City of Albuquerque

June 11, 2002

RE: Anderson Warehouse Grading and Drainage Plan (J14-D142)
Engineer's Stamp Dated May 16, 2002

SHEET TITLE: GRADING AND DRAINAGE PLAN  
DRAWN BY: REFC

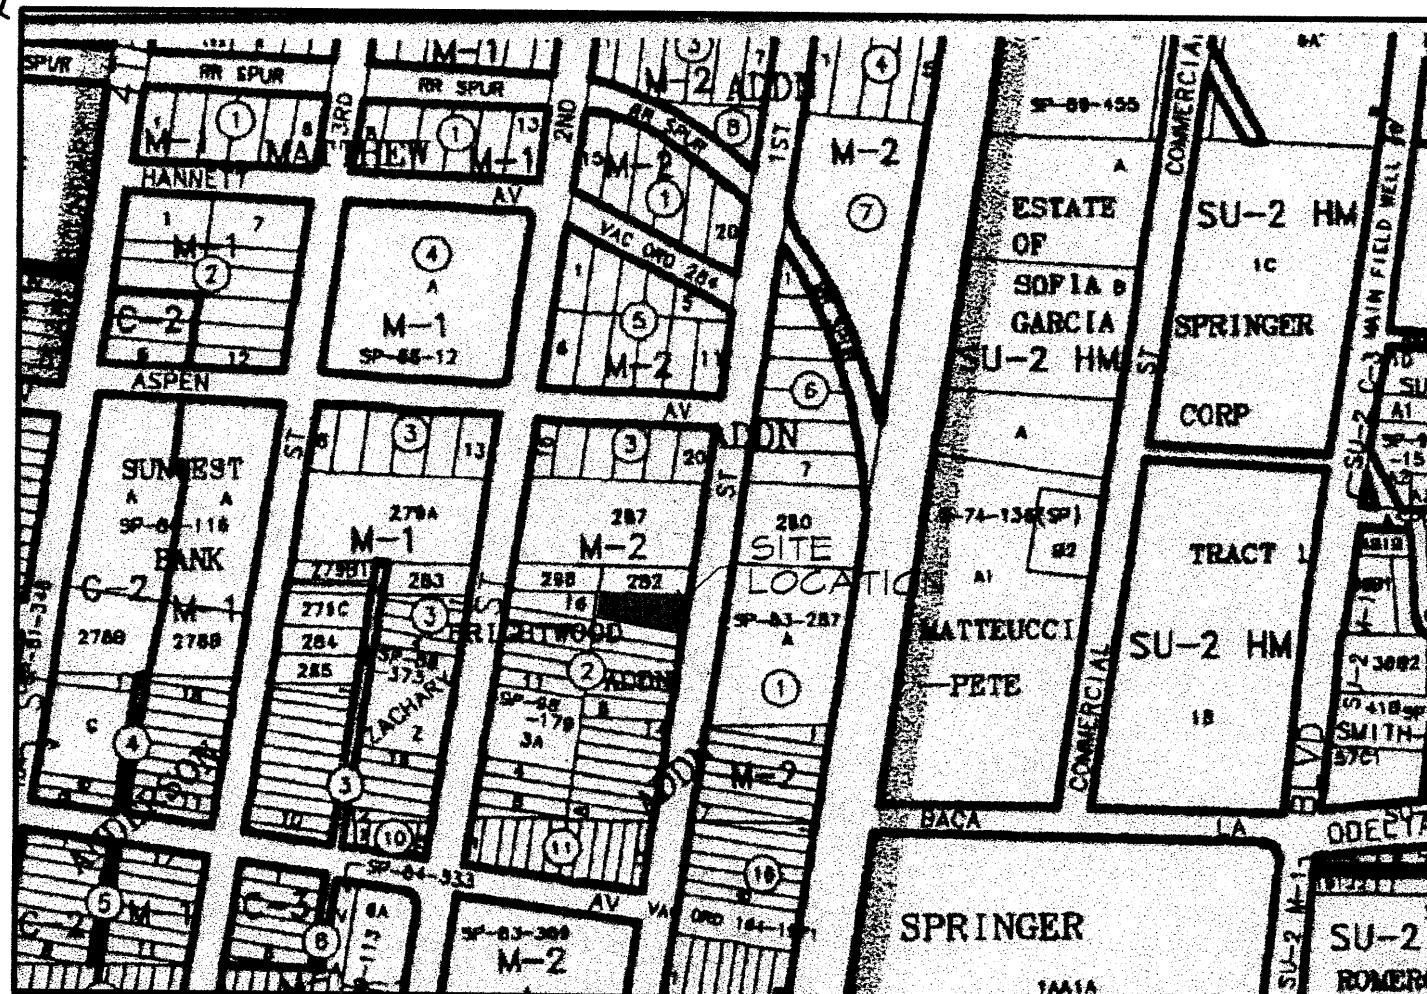
- Please address if there are any off-site flows. If there are none, please state so in your commentary.
- First Street is located within a 100-year floodplain (AO-1'). The finish floor needs to be elevated one-foot above the floodplain elevation.
- With the one-foot water block, how is the runoff from the site going to discharge to the street? As long as the building is elevated the water block can be removed.
